NSW RURAL FIRE SERVICE

Your reference: MP08_0194 Mod 3
Our reference: D11/0019
DA15111099299AB

Agency Comment Kings Forest Project Approval, Tweed Coast Road, Kingscliff - Modification 3 Kings Forest Service Station

Scale	Date	Job Number	
1:2500@A3	NOV 2015	738.12	
Drawn	Stage	Drawing No.	Issue
PN	DA	0000	E

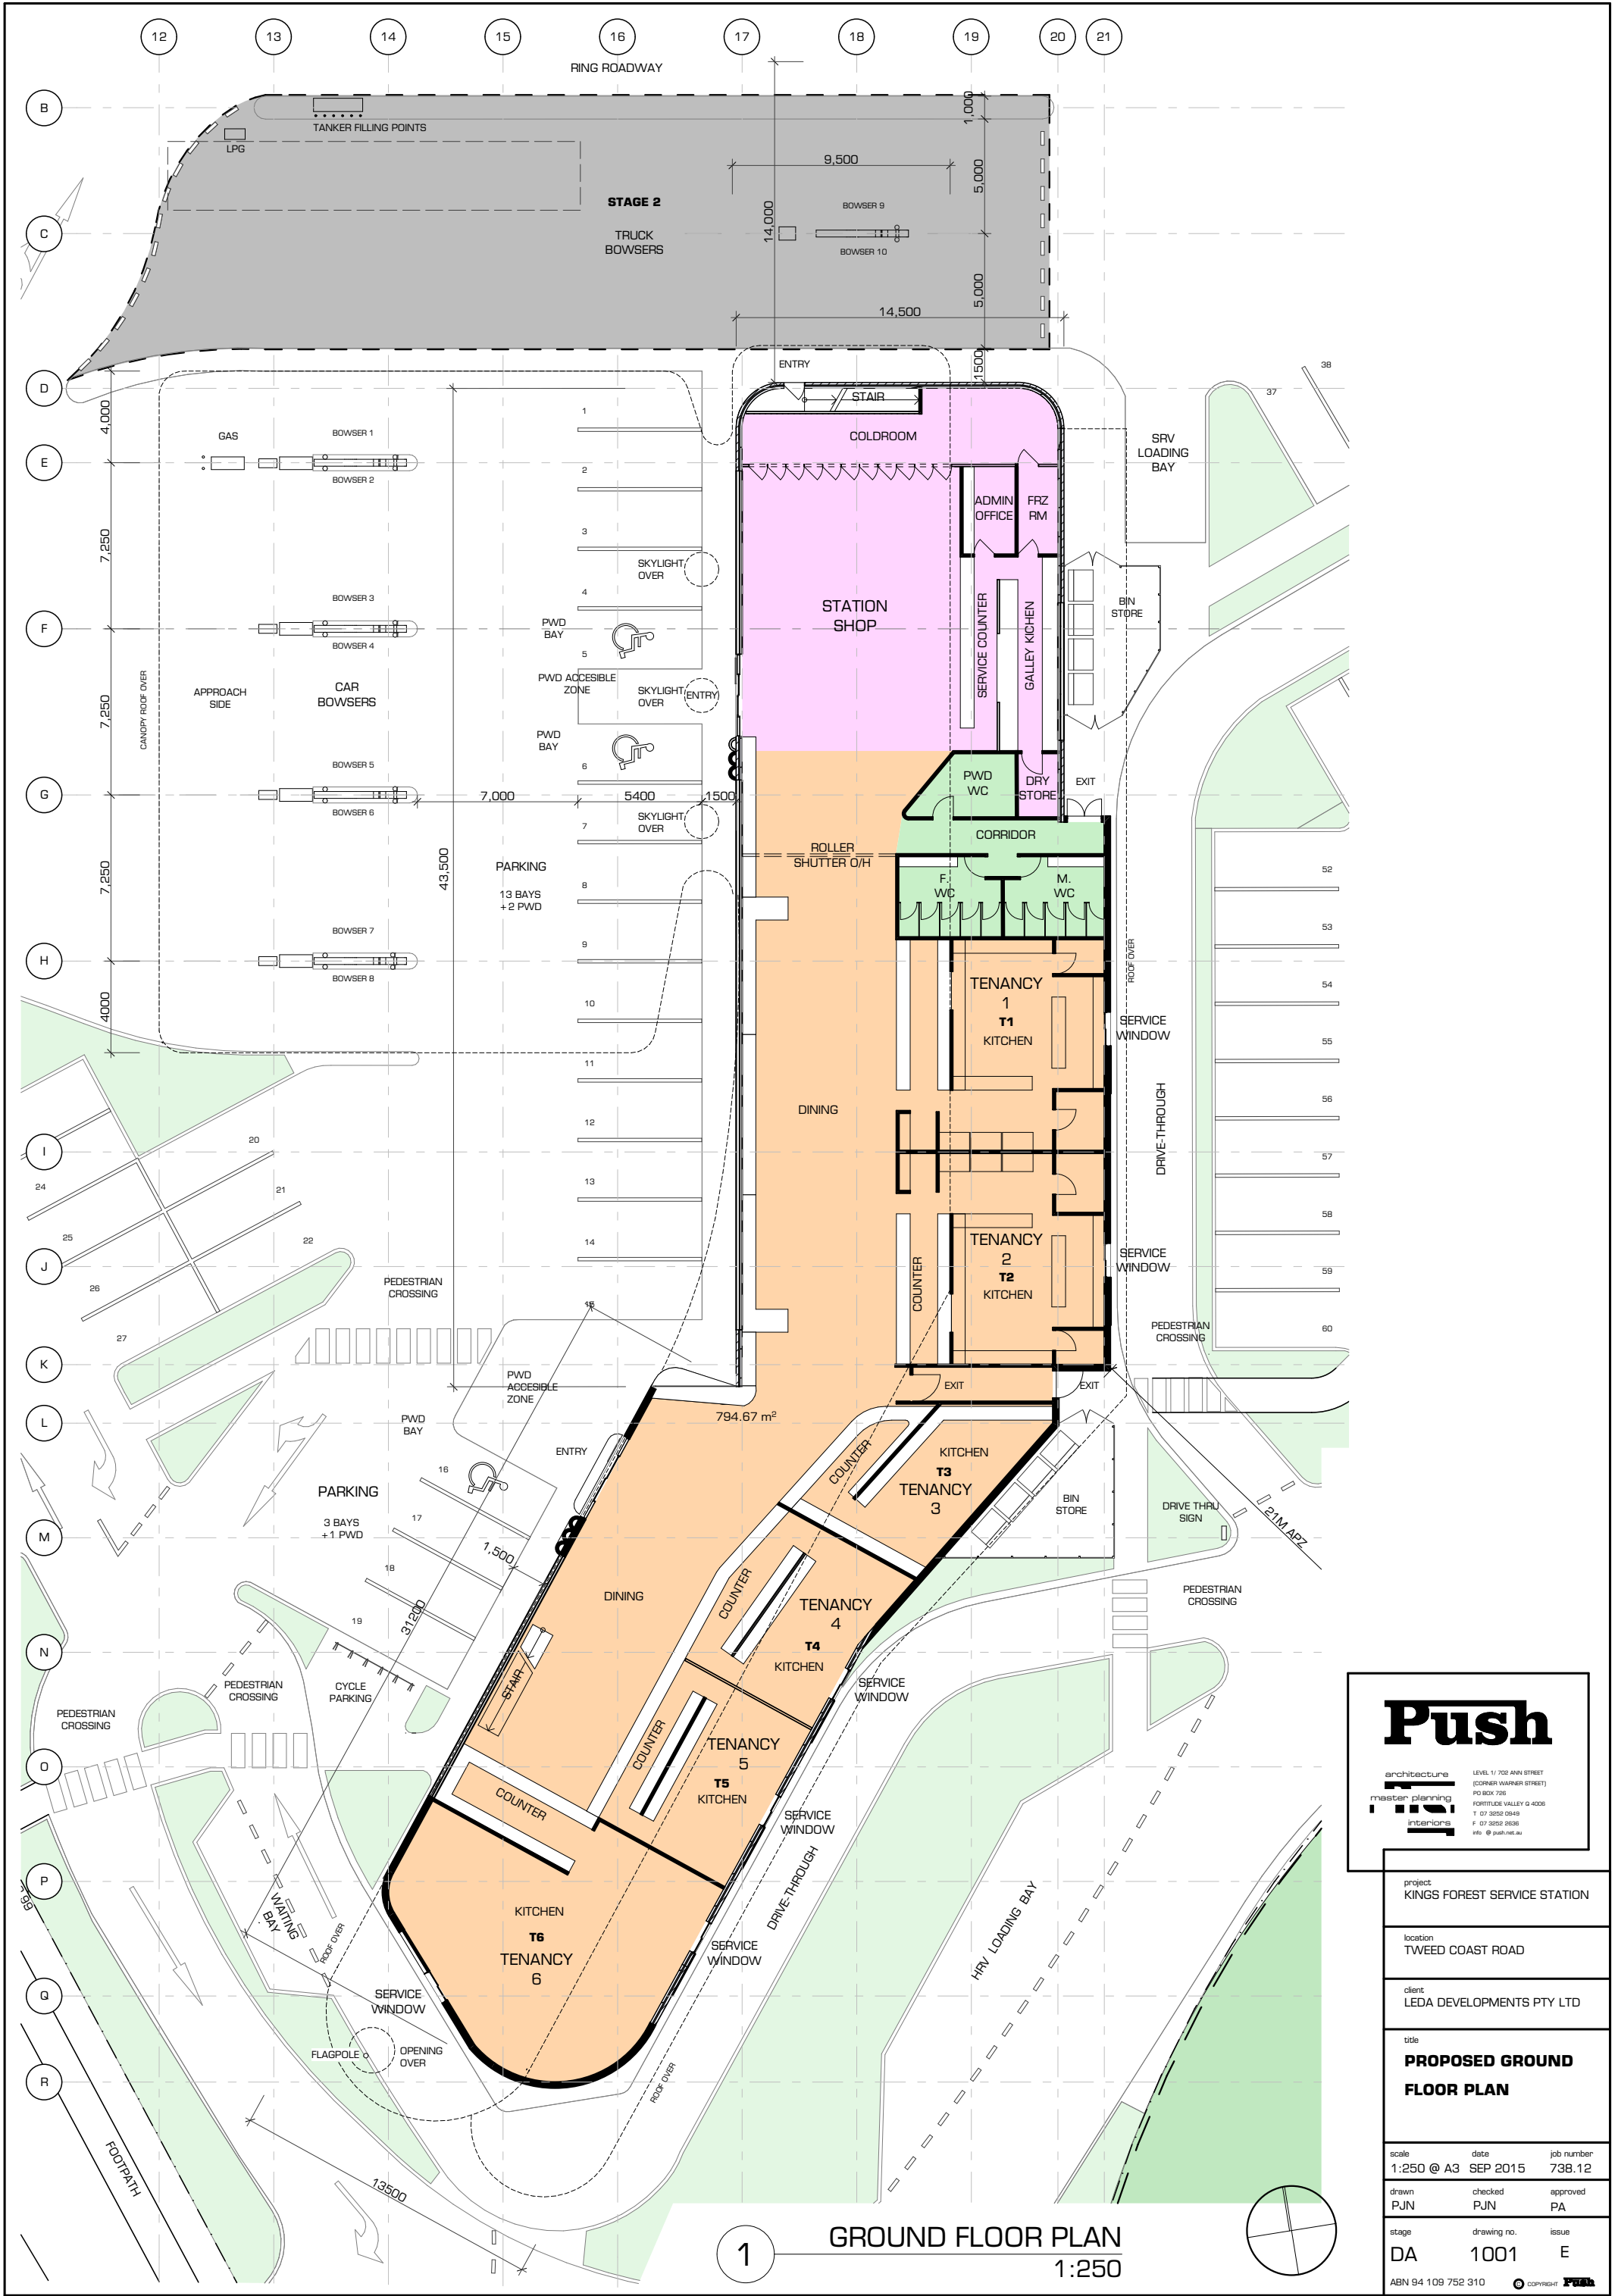
- The proposed tanker filling points, including above-ground ventilation infrastructure, should be located a minimum 7 metres from the north boundary and be designed to withstand 25 kWm² of radiant heat exposure;
- The proposed truck bowzers (stage 2) should be located a minimum 7 metres from the northern boundary and be designed to withstand 25 kWm² radiant heat exposure;
- No storage of any materials should be permitted within 7 metres of the northern boundary;
- At the commencement of building works and in perpetuity the land around the Service Station building for a distance of 21 metres or to the property boundary, shall be managed as an inner protection area (IPA) as outlined within section 4.1.3 and Appendix 5 of 'Planning for Bush Fire Protection 2006' and the NSW Rural Fire Service's document 'Standards for asset protection zones';

Drawn PN Stage DA Drawing No. 2001 Issue D

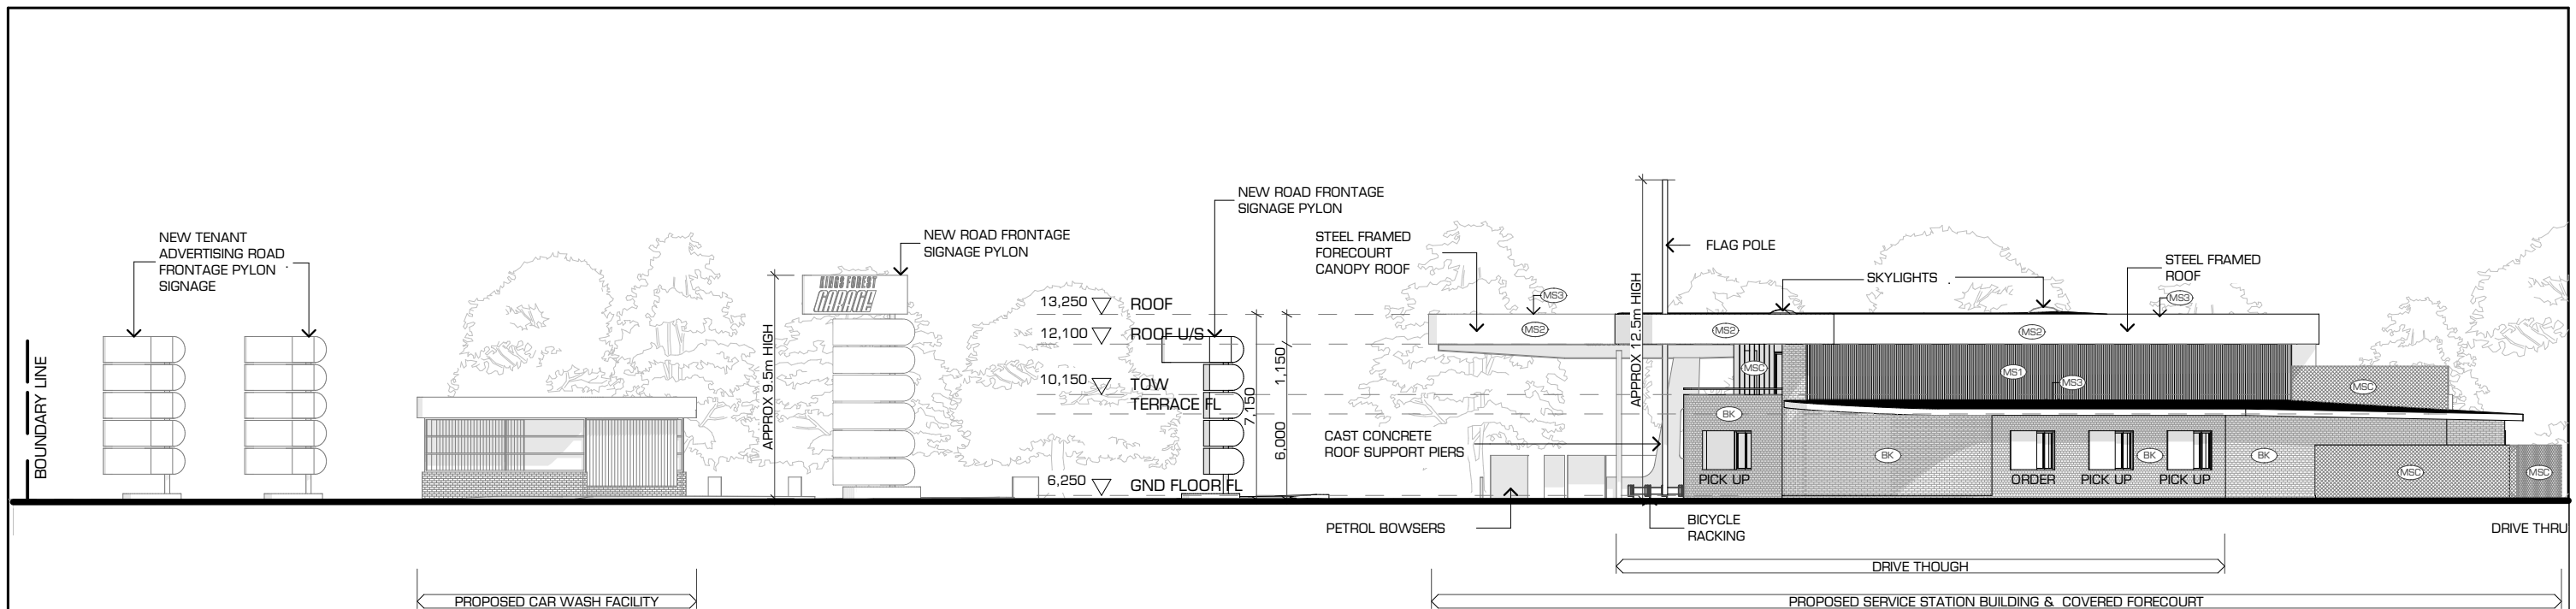
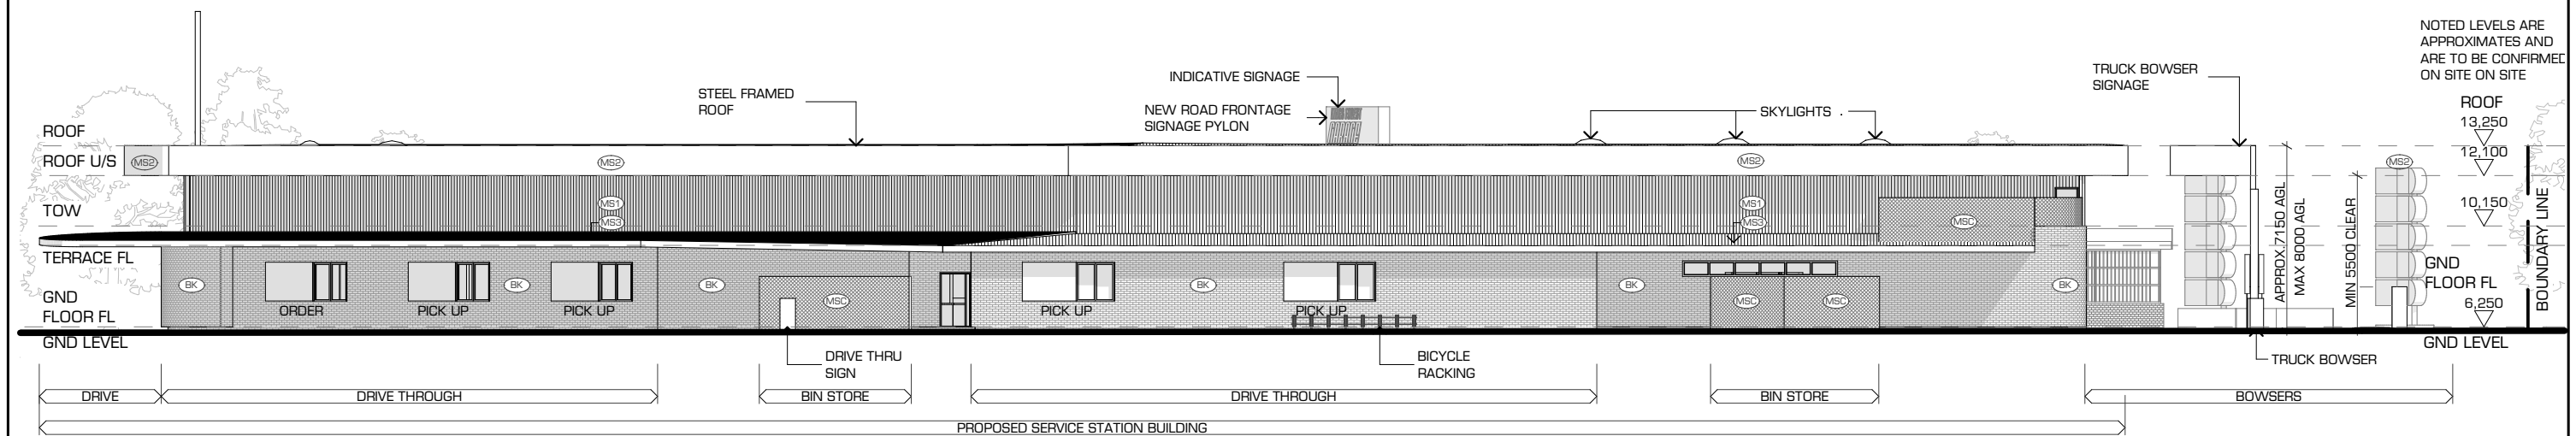
- The northern and eastern elevations of the proposed Service Station building shall be constructed to the requirements of Sections 3 and 7 (BAL 29) Australian Standard AS3959-2009 'Construction of buildings in bush fire-prone areas' and section A3.7 Addendum Appendix 3 of 'Planning for Bush Fire Protection';
- The southern and western elevations of the proposed Service Station building shall be constructed to the requirements of Sections 3 and 6 (BAL 19) Australian Standard AS3959-2009 'Construction of buildings in bush fire-prone areas' and section A3.7 Addendum Appendix 3 of 'Planning for Bush Fire Protection';
- Water, electricity and gas are to comply with the following requirements of section 4.1.3 of 'Planning for Bush Fire Protection 2006'.
